**SHOALHAVEN CITY COUNCIL
ENVIRONMENTAL ASSESSMENT SUBMISSION TO THE NSW DEPARTMENT
OF PLANNING
PART 3A, ENVIRONMENTAL PLANNING & ASSESSMENT ACT, 1979**

MAJOR PROJECT APPLICATION - SSD 4952

Shoalhaven Cancer Care Centre

COUNCIL REFERENCE: 3A11/1002

DRAWING NUMBER
SC-A004

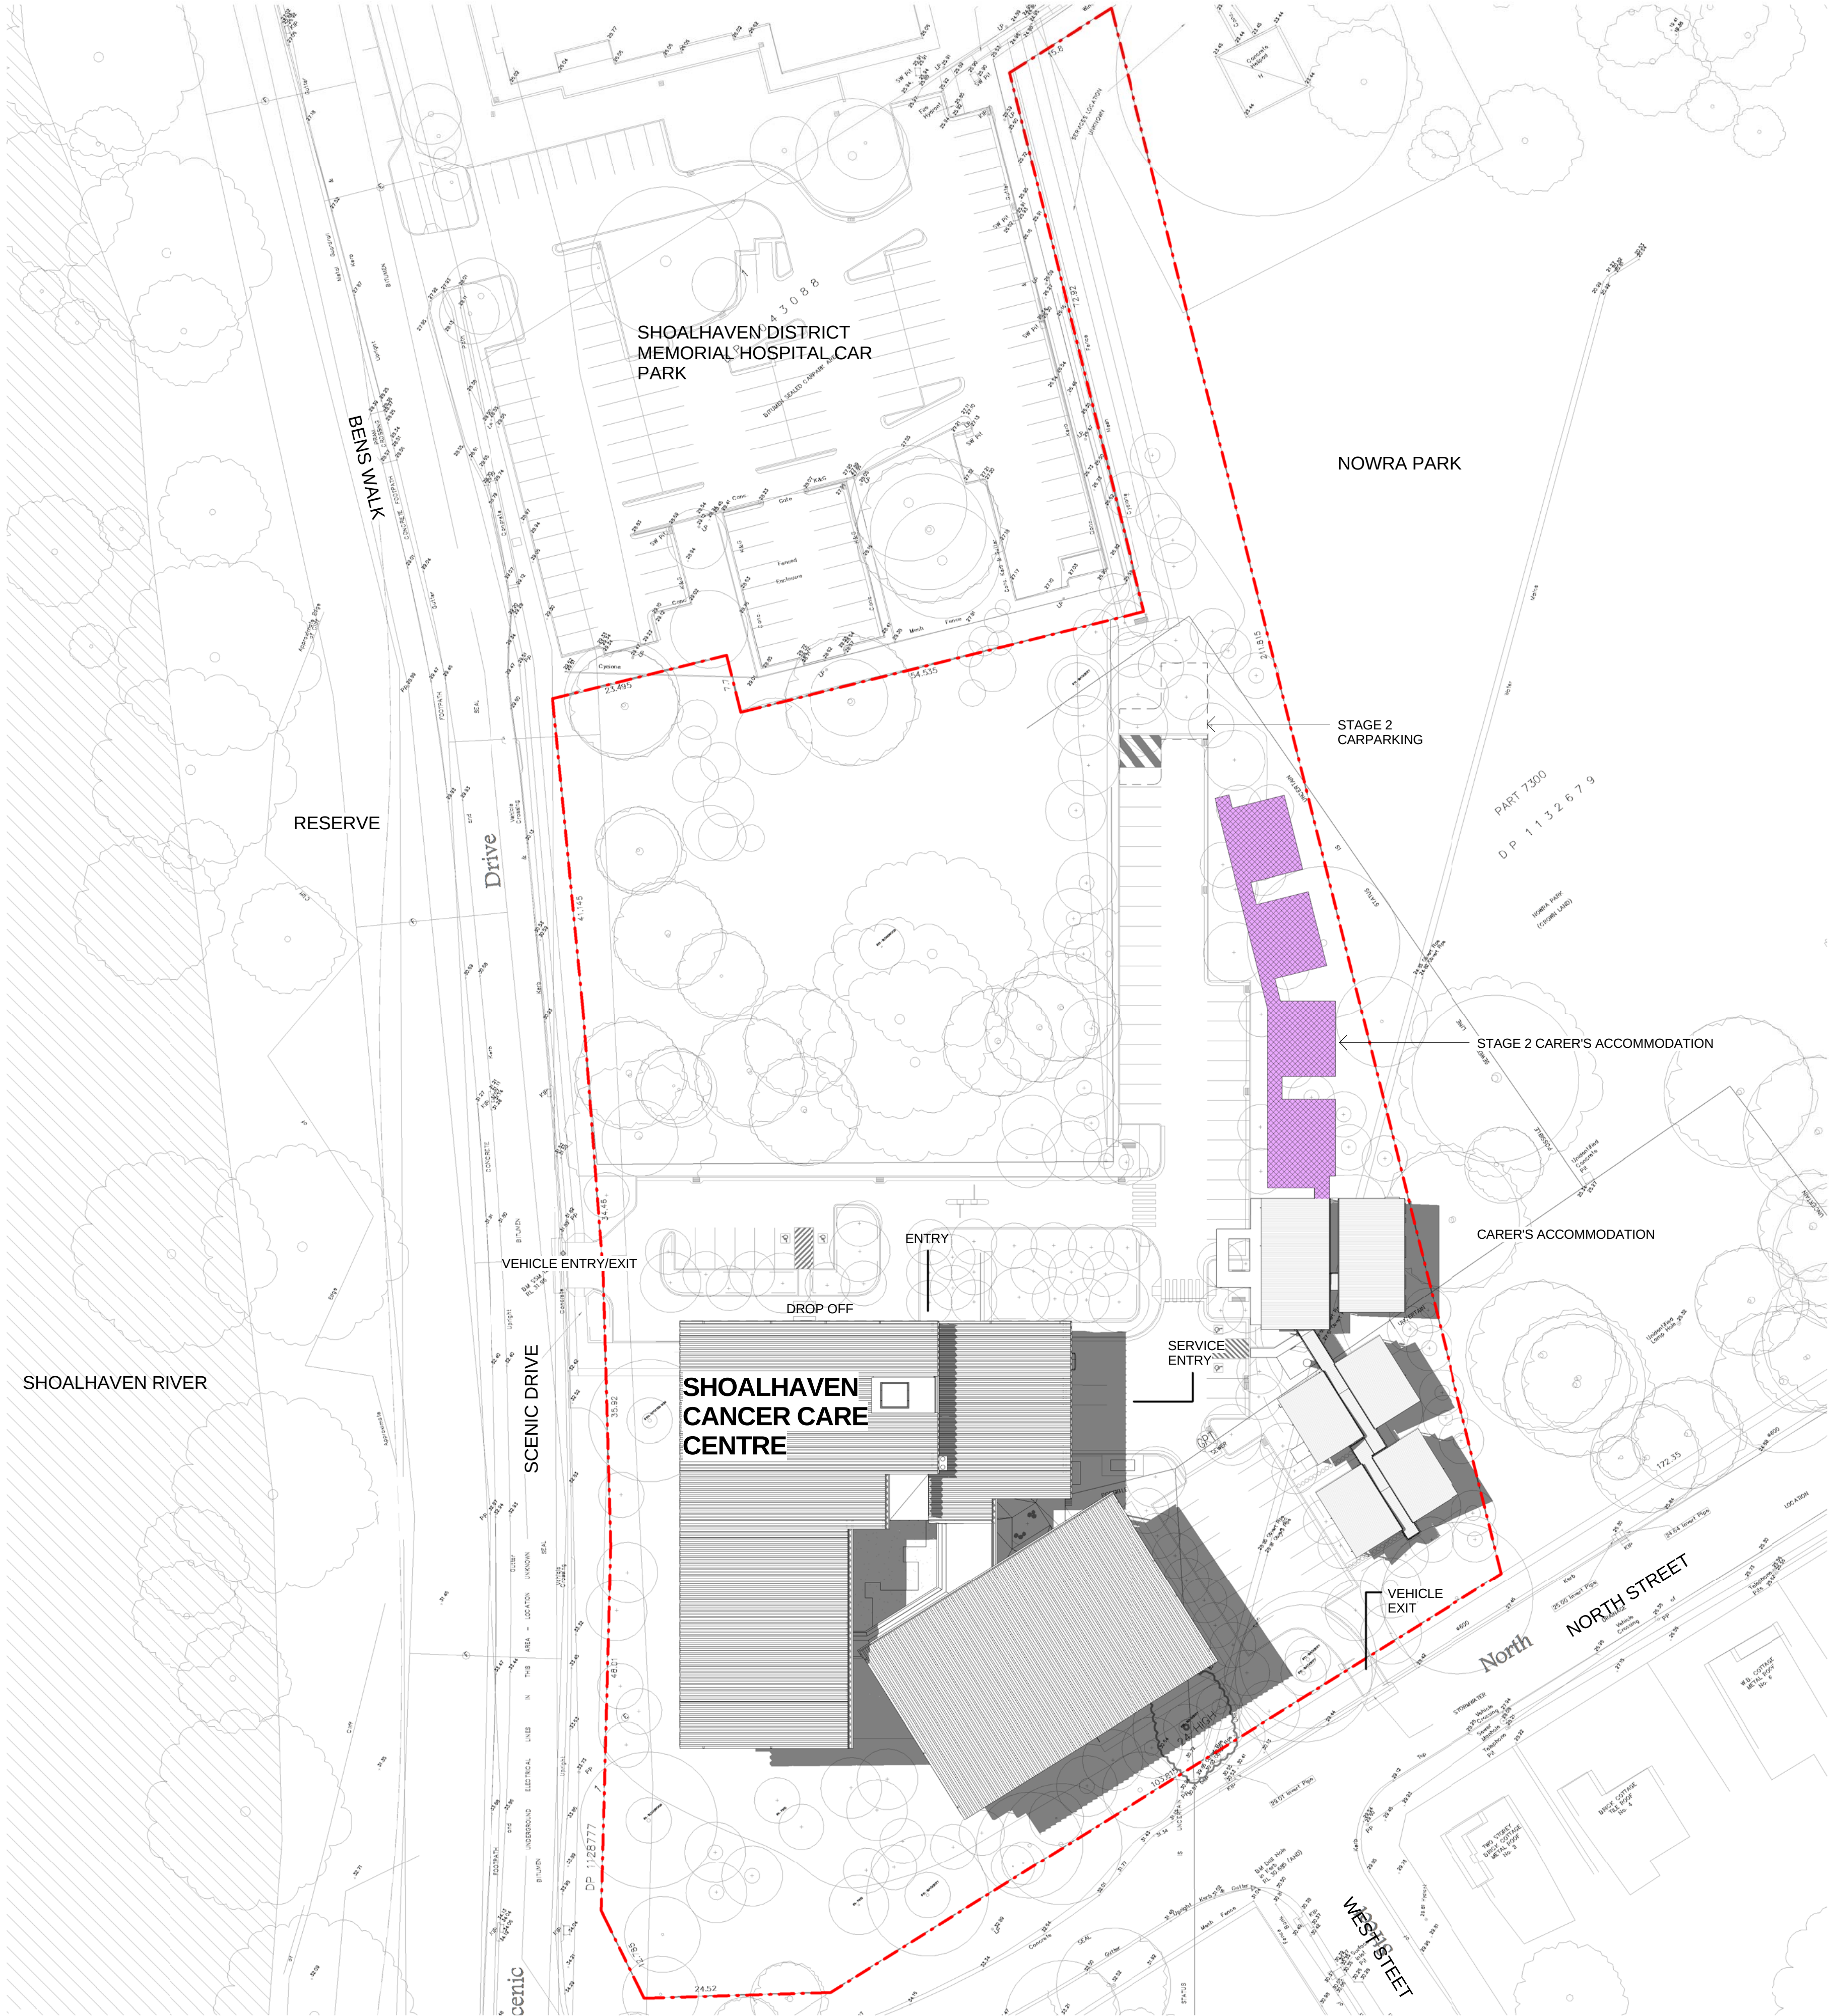
- (a) TTW Clause 3.1 outlines the proposed on-site traffic flow with two way entry/exit off Scenic Drive and one way exit to North Street. The site plan shows a traffic management "boom gate" system is proposed between the drop-off area and the other parking areas. The TTW report does not mention this measure. While not opposing this measure it appears that larger and delivery vehicles as well as ambulances will require a management system in place to utilise the boom gates.

Council requests this measure be reviewed for practical purposes.

- (b) TTW Clause 3.2 states that 62 car spaces are to be provided, with a schedule of parking rates. The proposed site plans (drawings SC-A004 and SC-A005) include parking layouts that vary and also refers to a "stage 2 car parking" at the northern end. There is no description of what the stage 2 will deliver onsite.

Council considers additional car parking is required for patients requiring accommodation rather than the 5 car spaces being proposed. It is considered that for a regional facility provisions for small bus parking during the day (eg, community transport or similar) should also be included in car parking calculations.
